CITY OF ALBUQUERQUE

December 28, 2022

Re: Hanover Studios
6500 Hanover Rd. NW
30-Day Temporary Certificate of Occupancy
Transportation Development Final Inspection
Architect's Stamp dated 05-03-22 (J10-D040A)
Certification dated 12-14-22

SHEET TITLE
SITE PLAN FOR ADMINISTRATIVE AMENDMENT

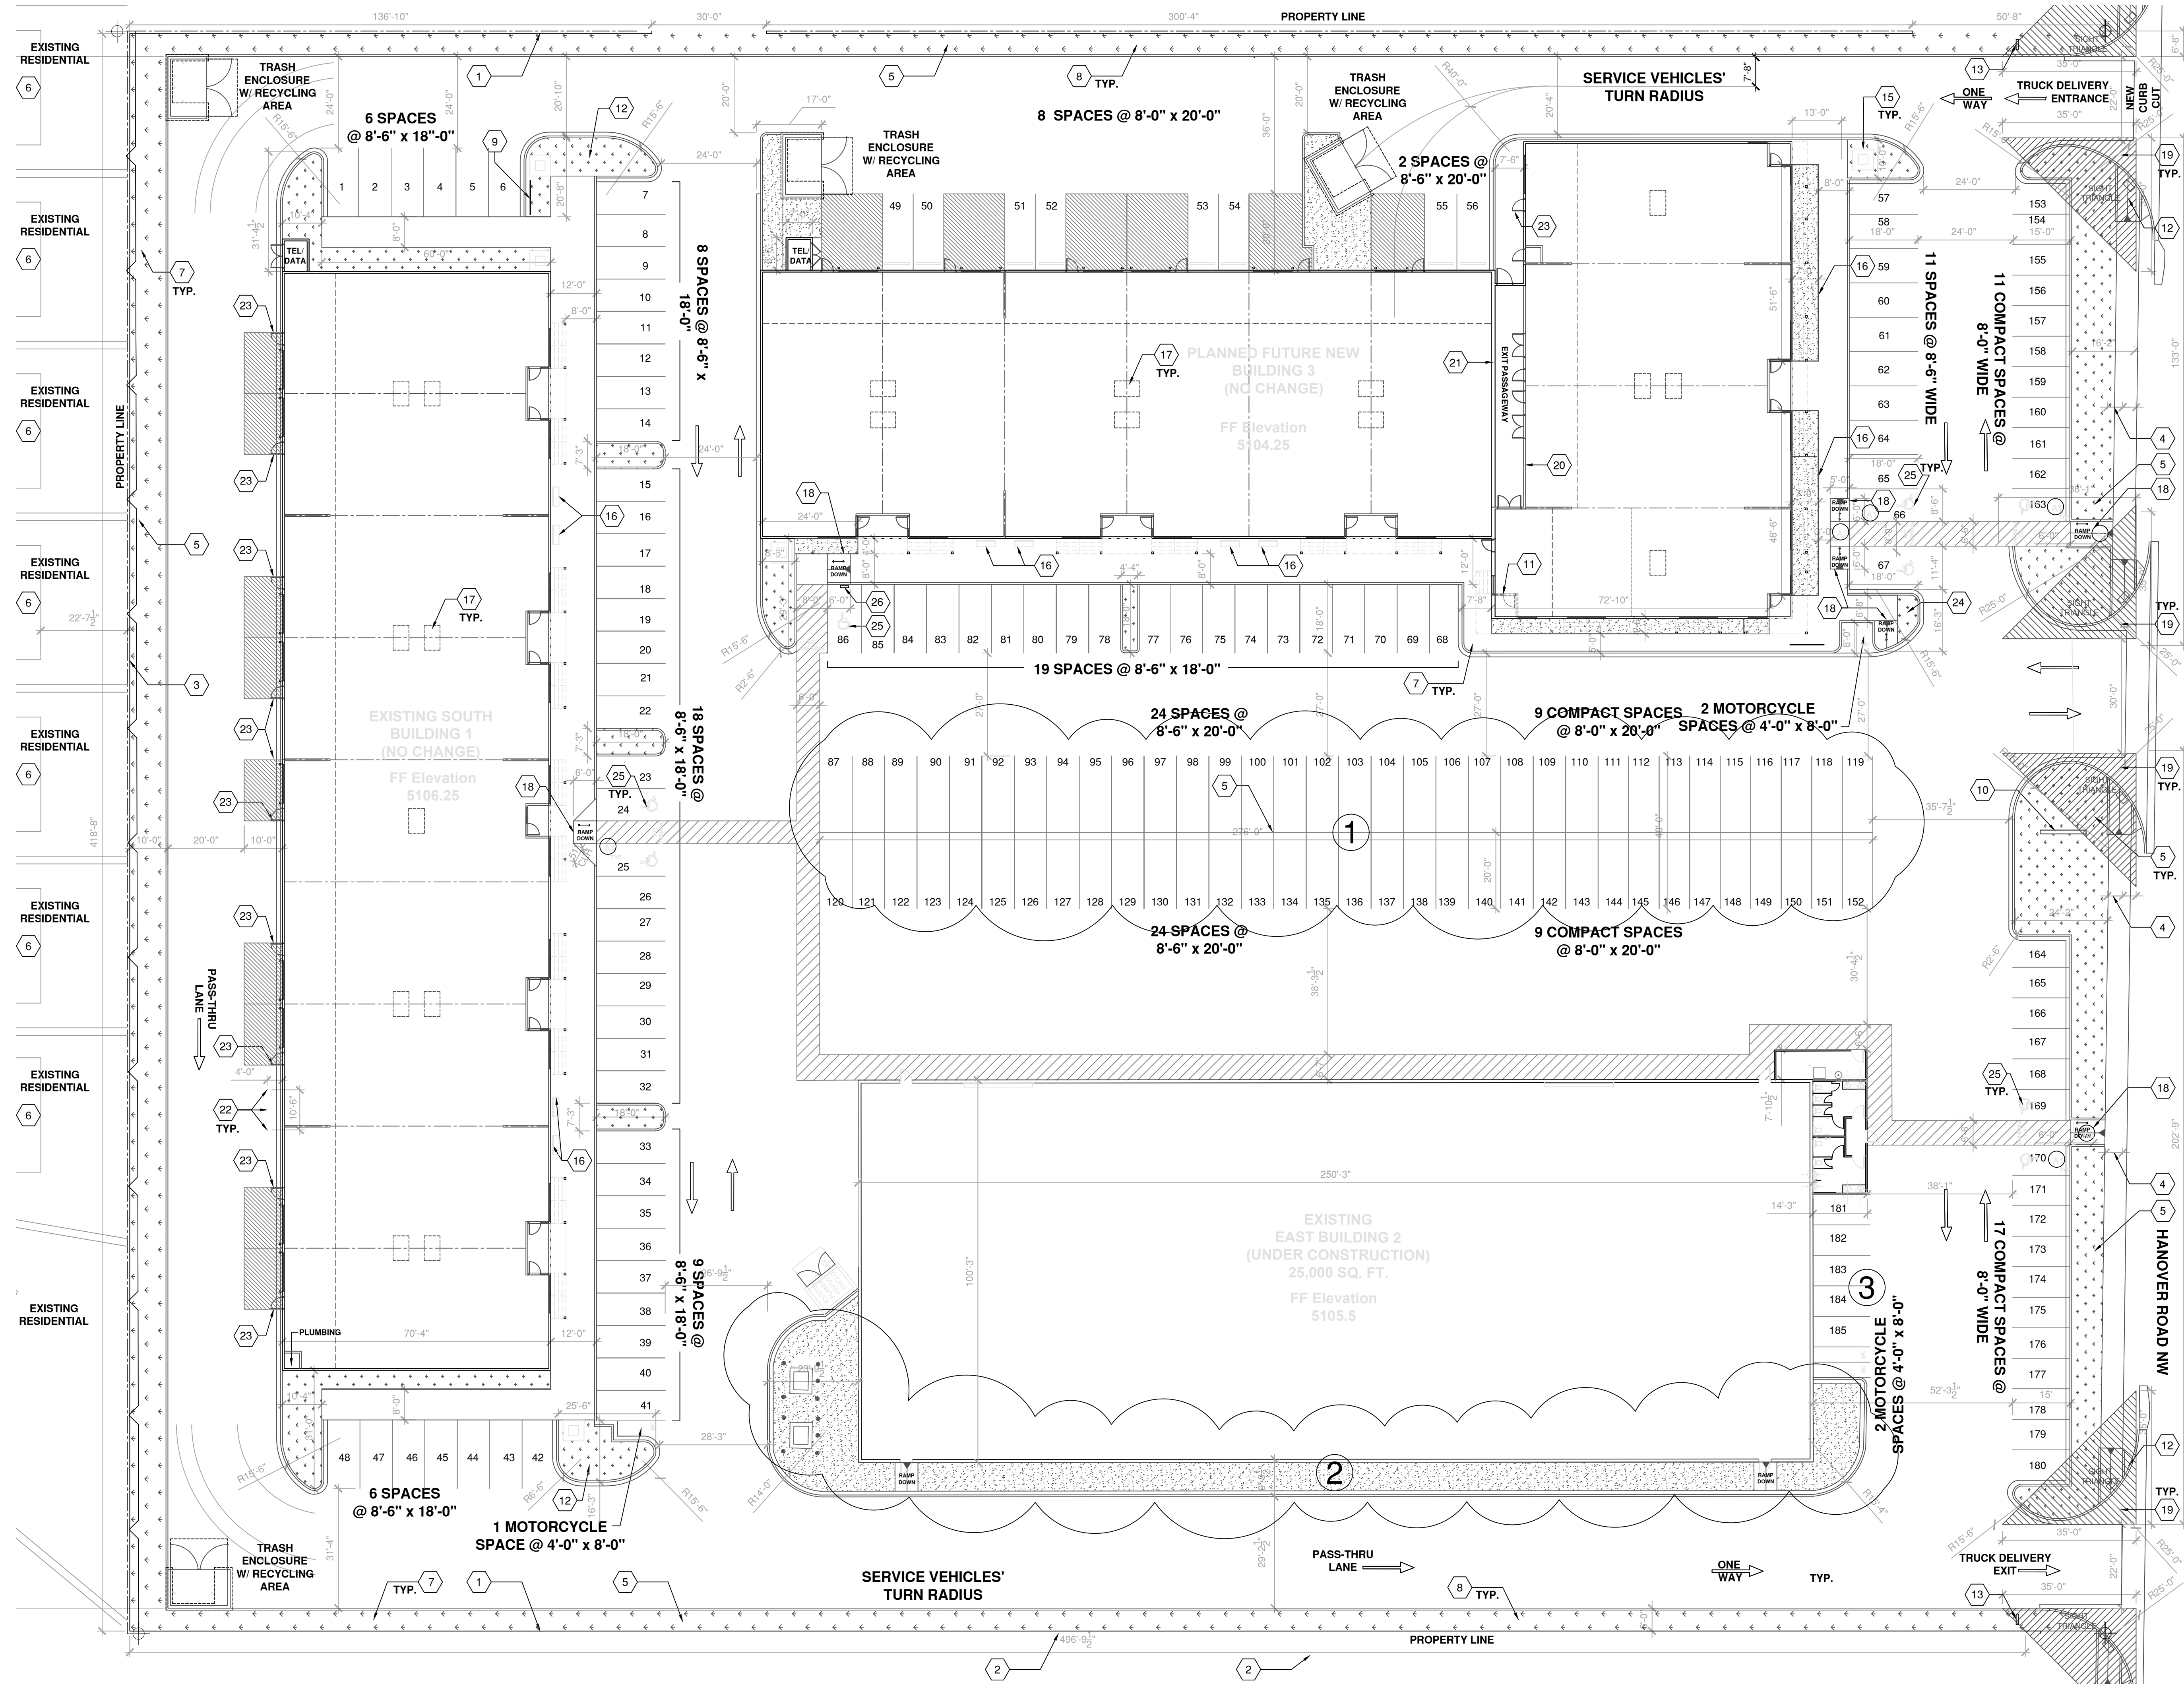
- Please update the existing ADA parking signs to the most current standard.
- Provide ADA signs for the new ADA parking spaces
- The ADA accessible parking sign must have the required language per 66-7-352.4C NMSA 1978 **"Violators Are Subject to a Fine and/or Towing."** Please call out detail and location of signs.
- Provide Motorcycle parking signs.
- The pavement marking "MC" should be shown in the opposite direction for motorcycles entering the parking space.
- Please redline the plan to reflect the changes. Changes from the original key note 3, showing 5 parking spaces and 2 MC parking spaces, but per site visit, there were three regular parking spaces.
- Please fill the landscape at the same elevation as the sidewalk to avoid a tripping hazard. See attached picture.
